WEST SUSSEX COUNTY COUNCIL CONSULTATION

TO:	Arun District Council FAO: A Wood
FROM:	WSCC - Highways Authority
DATE:	17 December 2020
LOCATION:	38 Arundel Road Littlehampton BN17 7DB
SUBJECT:	LU/327/20/PL Application under Regulation 3 of the Town and Country Planning (General Regulations) 2015 for the change of use of single dwellinghouse to 2 No. residential apartments & associated external alterations. This site is in CIL Zone 4 (Zero Rated) as flats.
DATE OF SITE VISIT:	n/a
RECOMMENDATION:	Advice
S106 CONTRIBUTION TOTAL:	n/a

DRAWING TITLE
 PROPOSED FLOOR PLANS

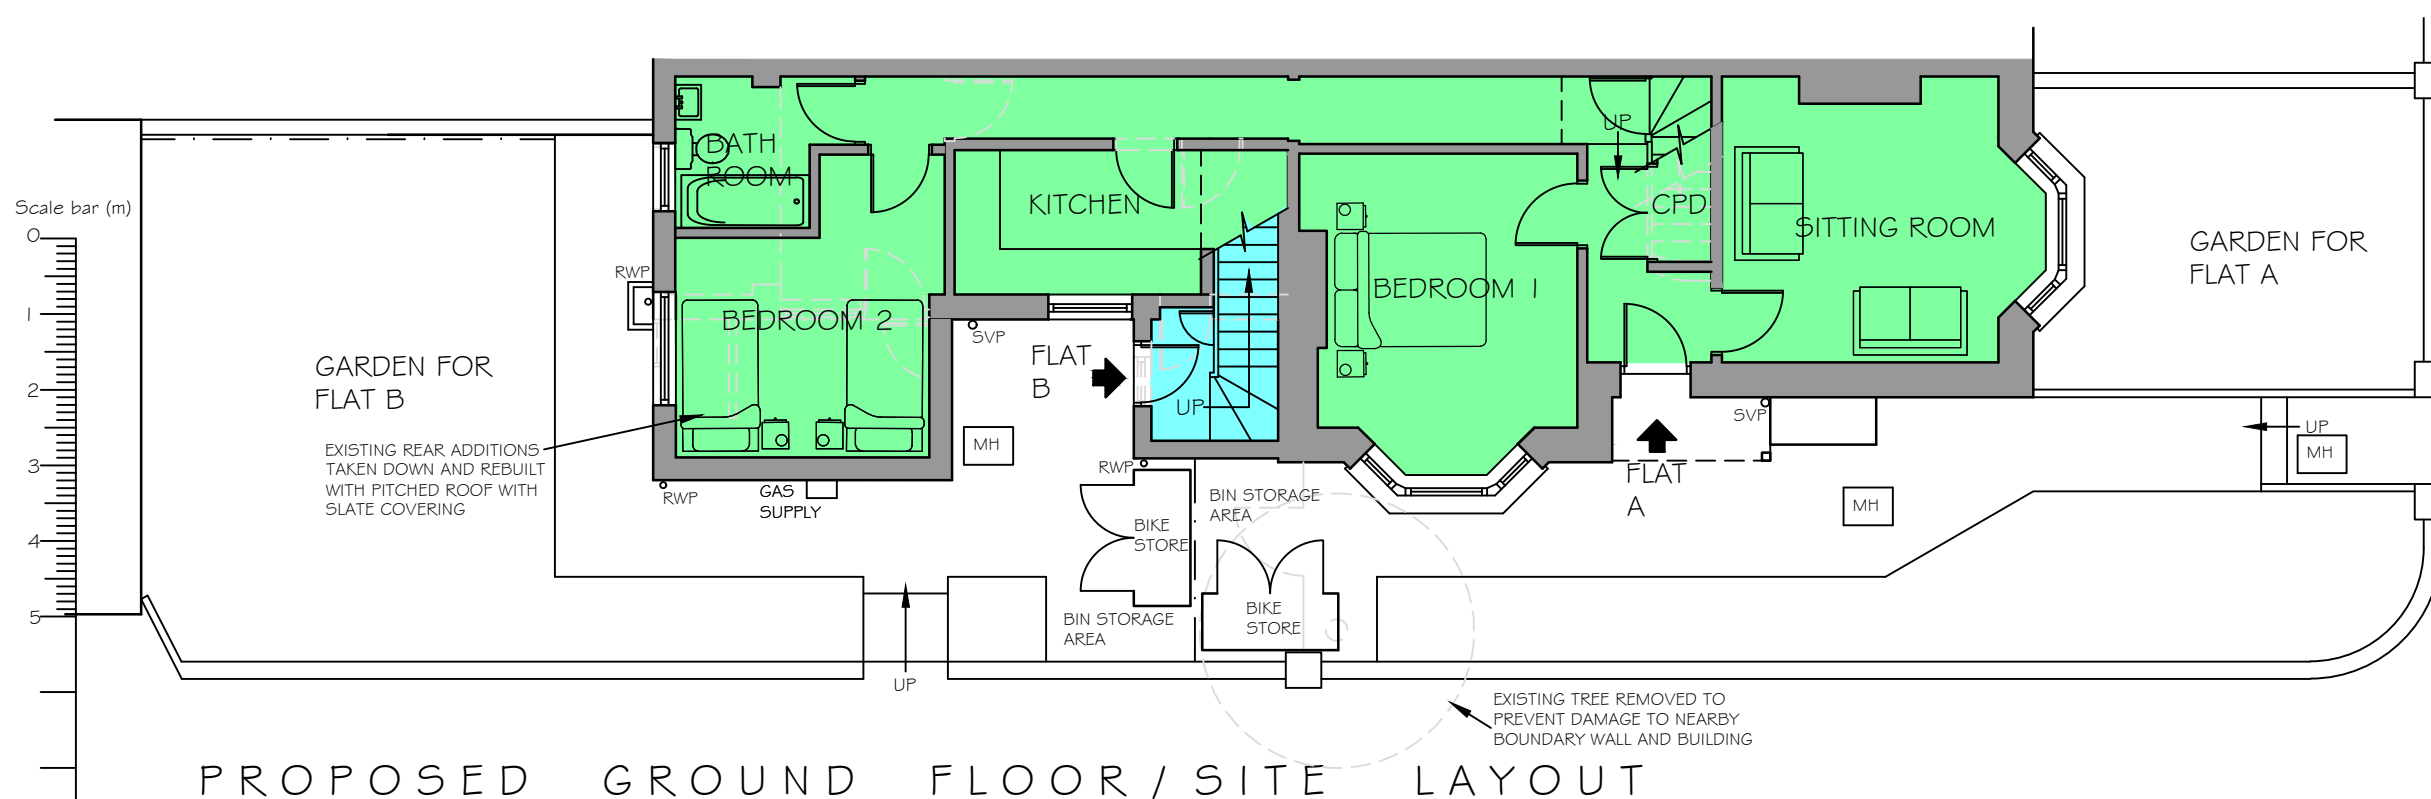
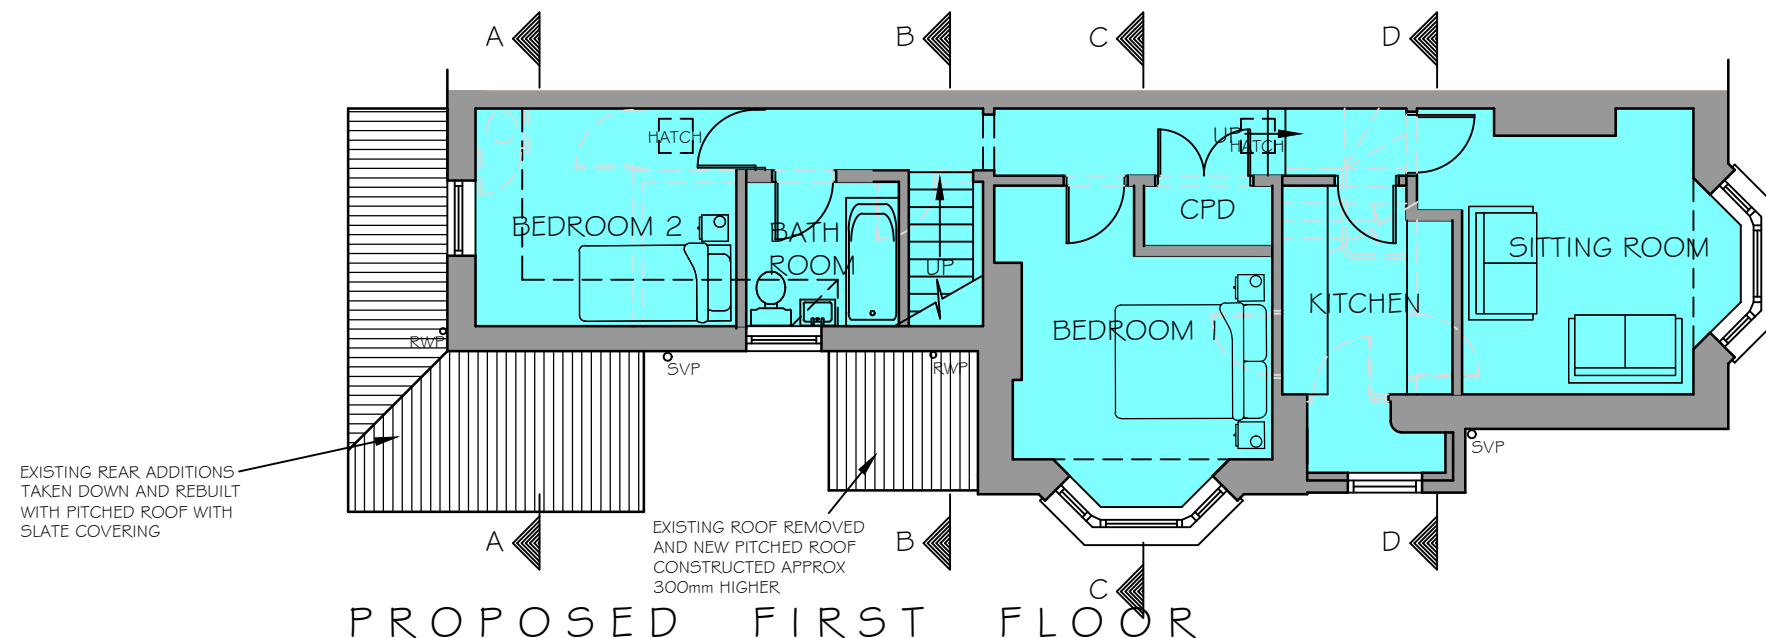
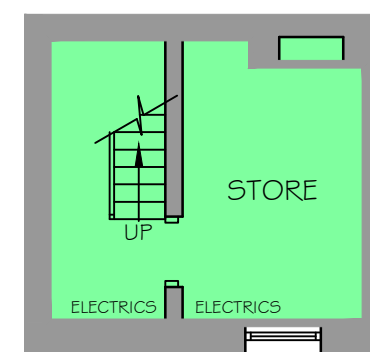
The proposed plans demonstrate that secure and covered cycle storage will be provided for each flat to encourage sustainable transport methods. The site is located within walking distance of Littlehampton town centre, bus stops and Littlehampton train station, reducing the reliance upon the private car.

No part of the development shall be first occupied until covered and secure cycle parking spaces have been provided in accordance with the approved plan.
